# **OXFORDSHIRE COUNTY COUNCIL'S RESPONSE TO CONSULTATION ON THE FOLLOWING DEVELOPMENT PROPOSAL**

**Application no:** 16/00264/FUL

**Proposal:** Construction of a road with associated infrastructure within the Heyford Park development

**Date:** 31 March 2016

HEYF-5-763 A

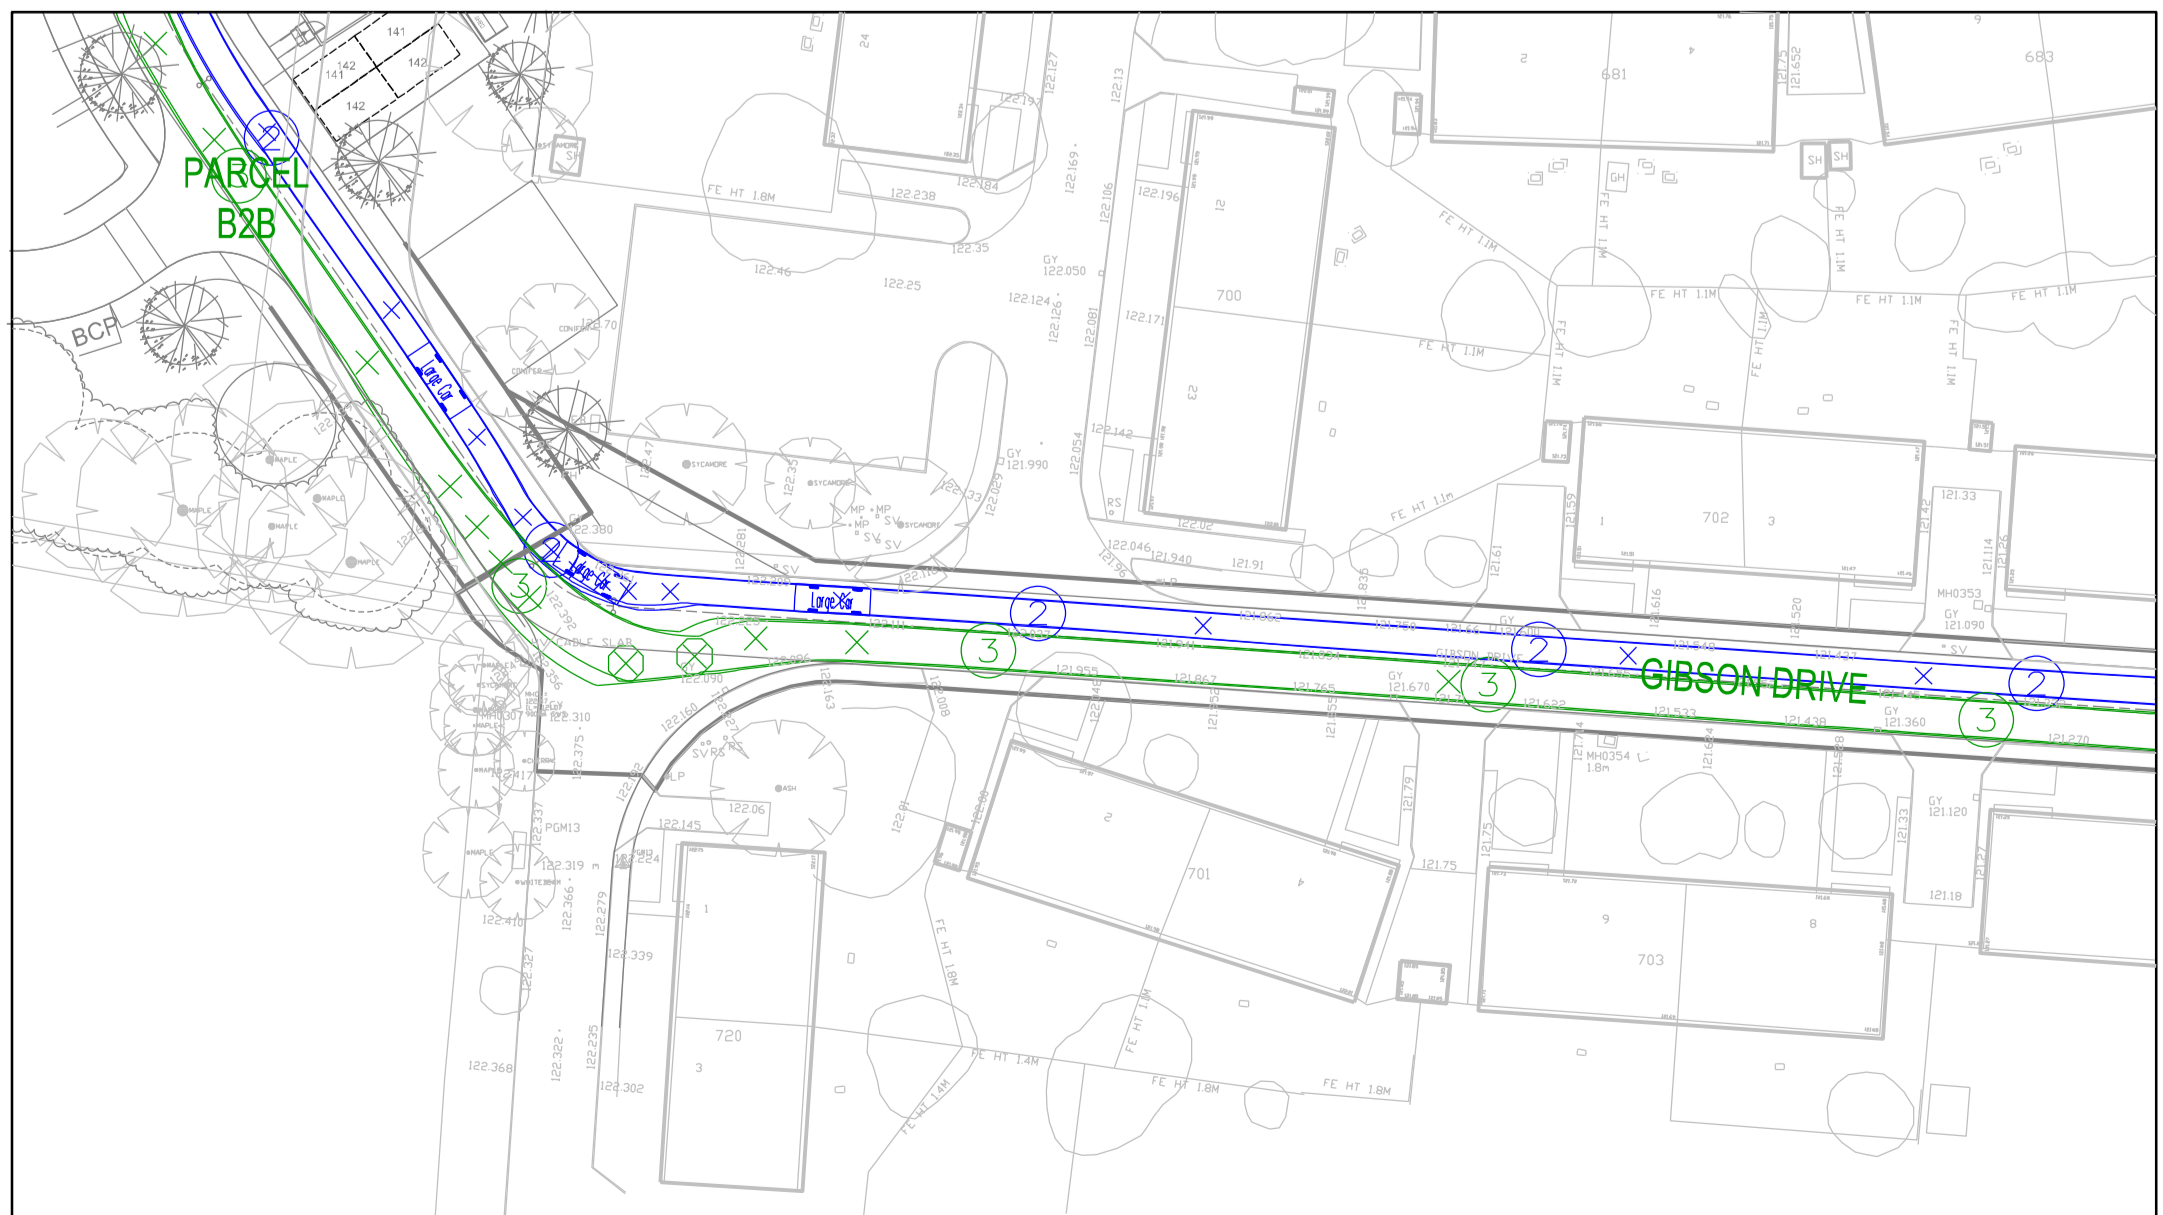
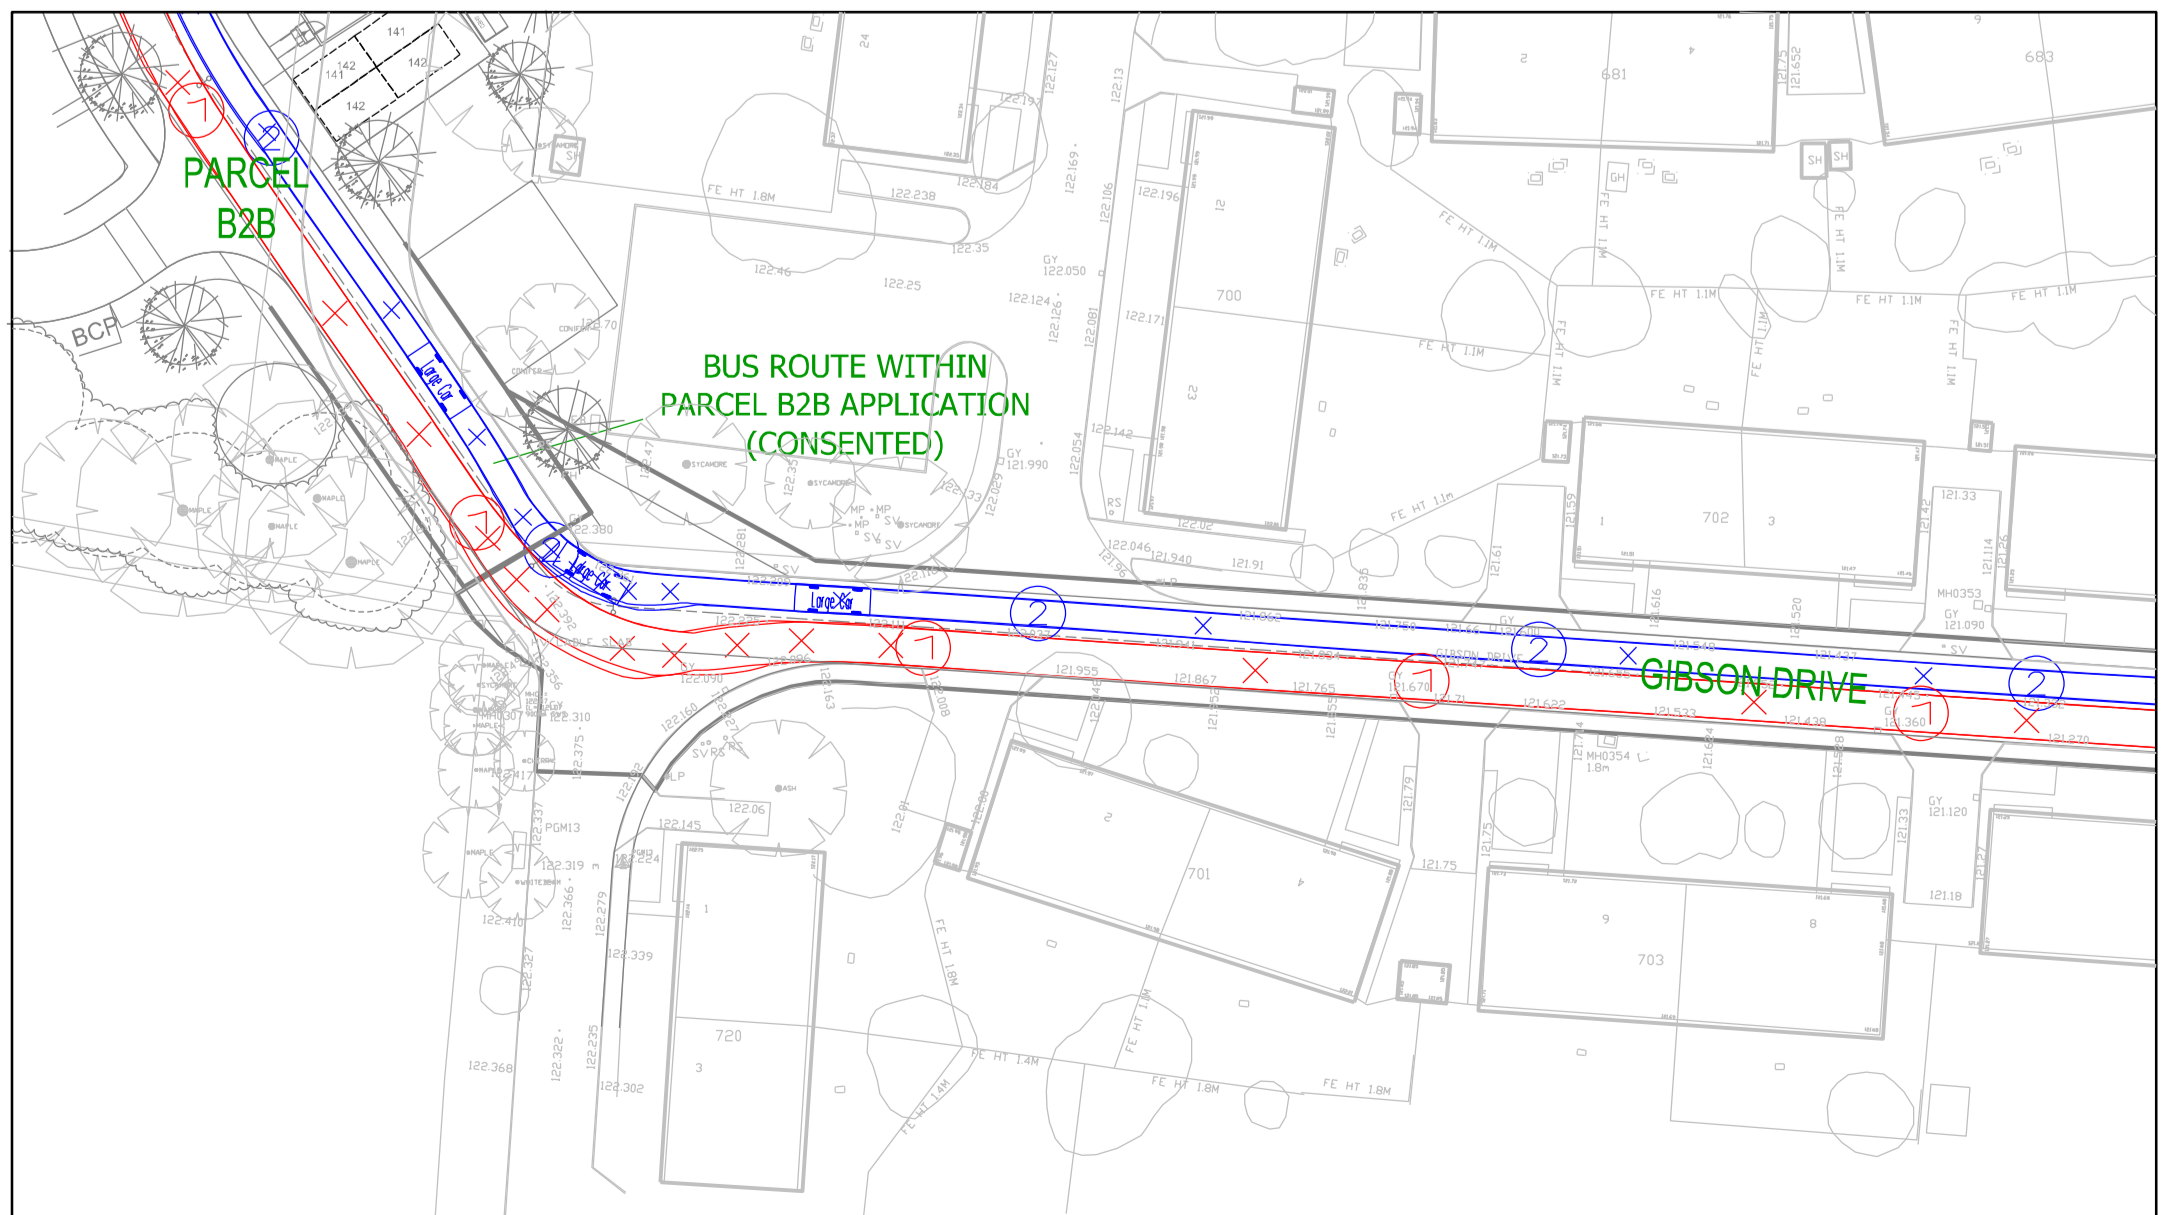
The application needs to be reassessed to take into account existing and future bus service routing in and around the Upper Heyford area. The road subject to the application is unlikely to be used by public buses.

The current 25A bus service is not commercially viable. It must attract additional patronage from the new residents to bridge the gap between costs and revenue. To do this the service must be attractive, reliable and direct, and not constrained by routeing around slow residential streets as this application appears to propose.

The current 25A bus service is scheduled to make the journey between Bicester and Oxford (via Upper Heyford) in approximately 55 minutes with two buses providing an hourly service. There is simply insufficient time in the schedule for this bus to make a detour around narrow slow-speed side roads, encumbered with build-outs and parked vehicles. The economics of this bus operation cannot sustain the cost of an additional vehicle which would be needed to cover the additional time required for this detour around the residential area.

HEYF-5-761 B

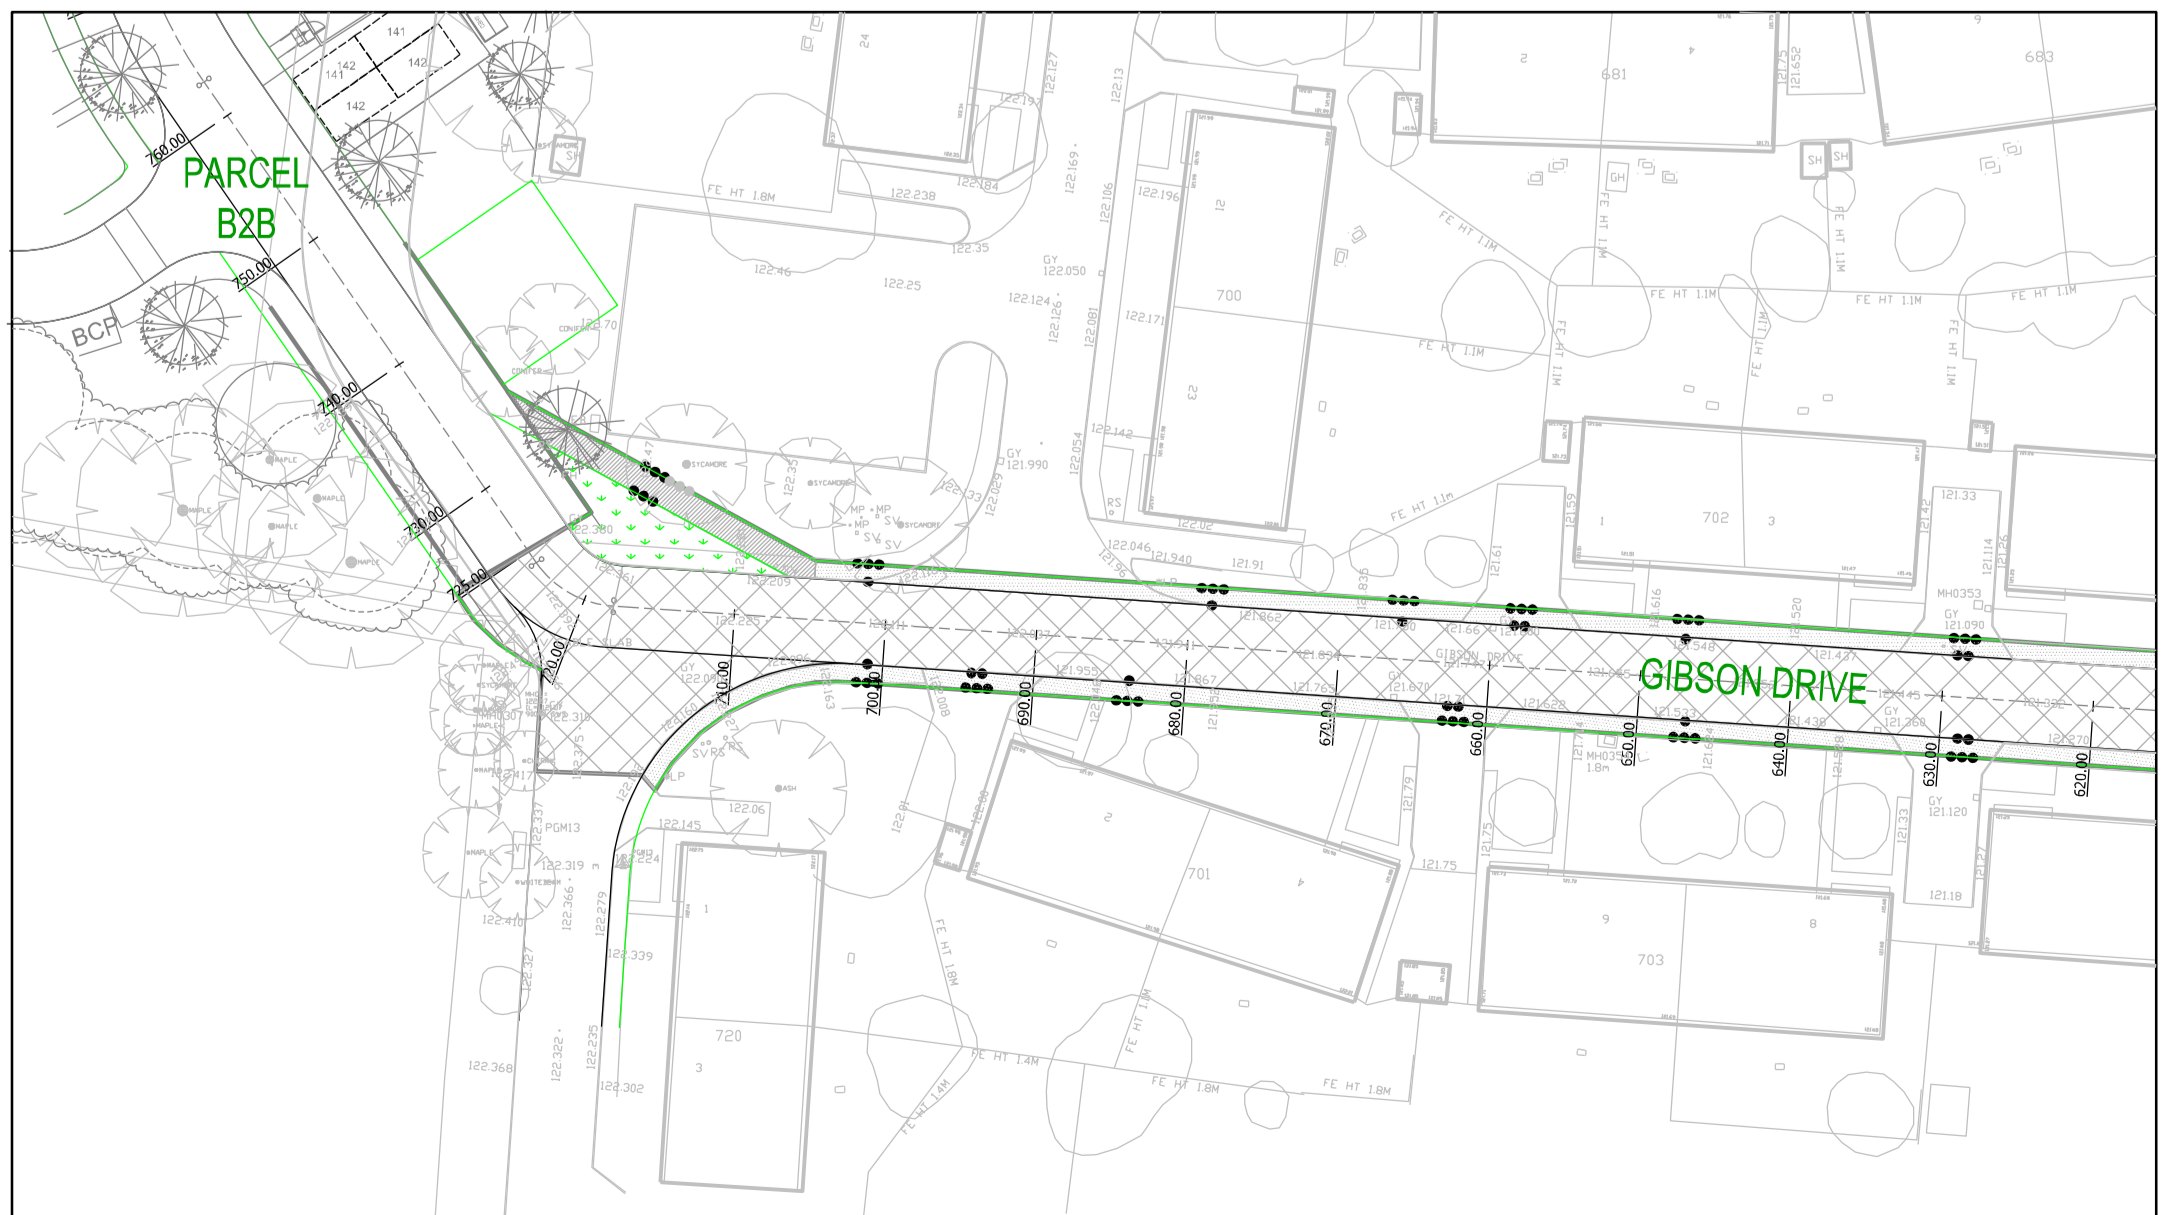
The General Arrangement on plan no.HEYF-5-760 B shows both private and highway storm water discharging into the same sewer line. Since April 2014 OCC standards do not allow for this. However, the Heyford Park Design Code precedes these new standards and does allow for this arrangement. If the road is intended for adoption then OCC would prefer the design

to demonstrate how private storm water will be kept separate and not impact on the highway system.

The access proposals and visibility splays at Camp Road, as shown on the General Arrangement plan no.HEYF-5-760 B, are acceptable. However visibility to the west is across the kerb line, and must therefore be maintained as unobstructed.

D7 Vision splay protection. The vision splays shall not be obstructed by any object, structure, planting or other material of a height exceeding 0.9m measured from the carriageway level.
